Application no: **3/2021/0954**

Address: **Old Sawley Grange Gisburn Rd Sawley BB7 4LQ**

Proposal: **Prior notification under class Q (a) and (b) for the conversion of the existing agricultural building to form 3 new dwellings.**

The Local Highway Authority have viewed the plans and highway related documents and have the following comments to make:

Working: Proposed Site Plan

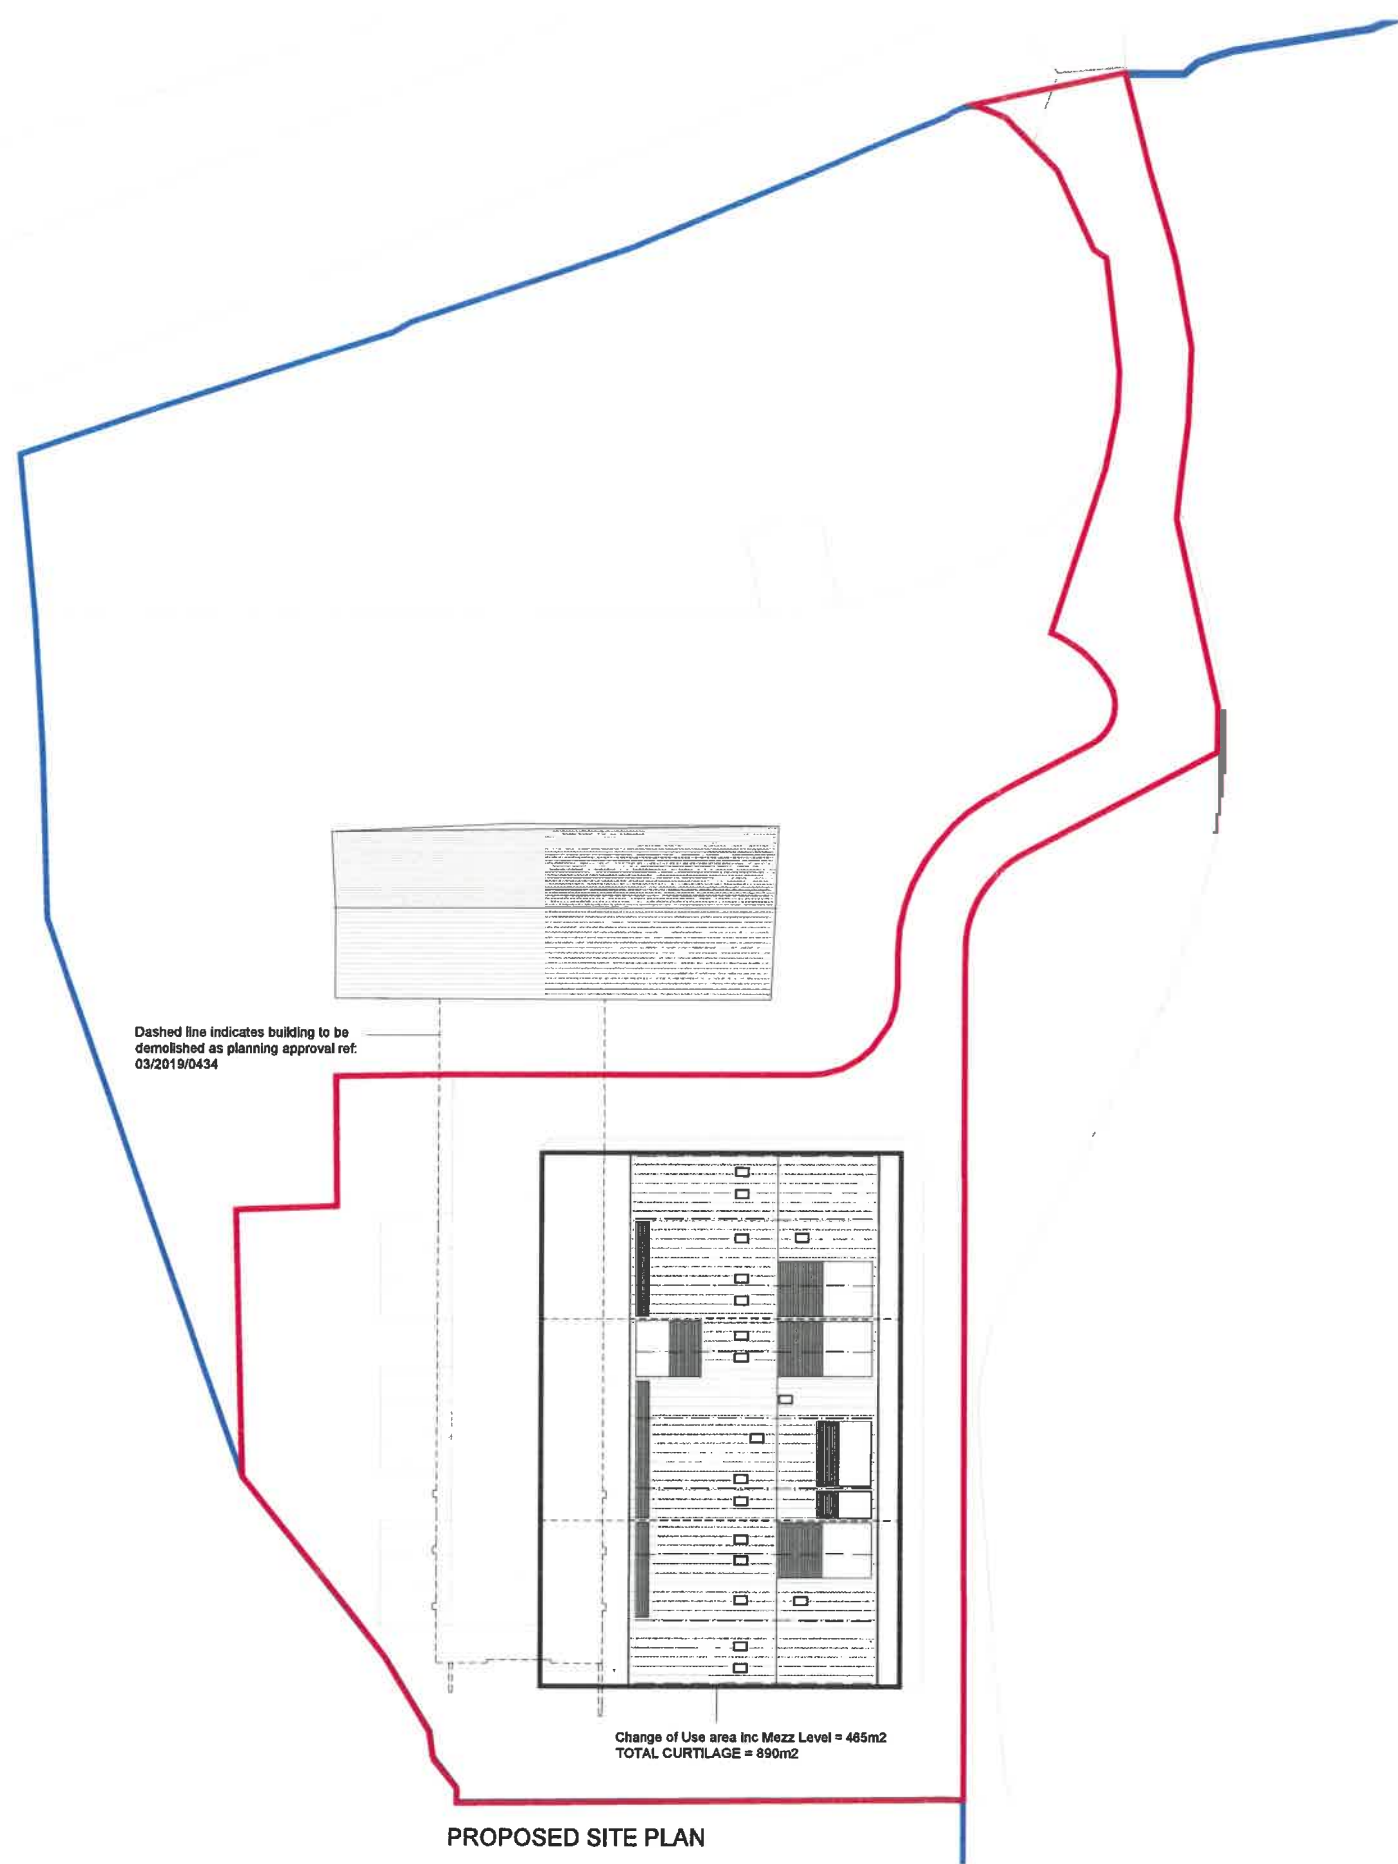
The LHA have now received LARK drawing number 05 titled " Proposed Site Plan" which was received by the LHA on 15th November 2021. This drawing along with all the other supporting documents will be reviewed below.

It is worth noting that a part of the office building which was permitted under application reference 3/2019/0434 will be demolished as part of this application, as shown on LARK drawing number 05 titled "Proposed Site Plan."

The LHA have reviewed LARK drawing number 05 titled " Proposed Site Plan" which was received by the LHA on 15th November 2021 and are satisfied that the parking arrangements comply with the parking guidance found in the Joint Lancashire Structure Plan and so the LHA have no objection to the proposal.

1. The development hereby permitted shall not be occupied until such time as the parking and turning facilities have been implemented in accordance LARK drawing number 05 titled " Proposed Site Plan" received 15th November 2021. Thereafter the onsite parking provision shall be so maintained in perpetuity.
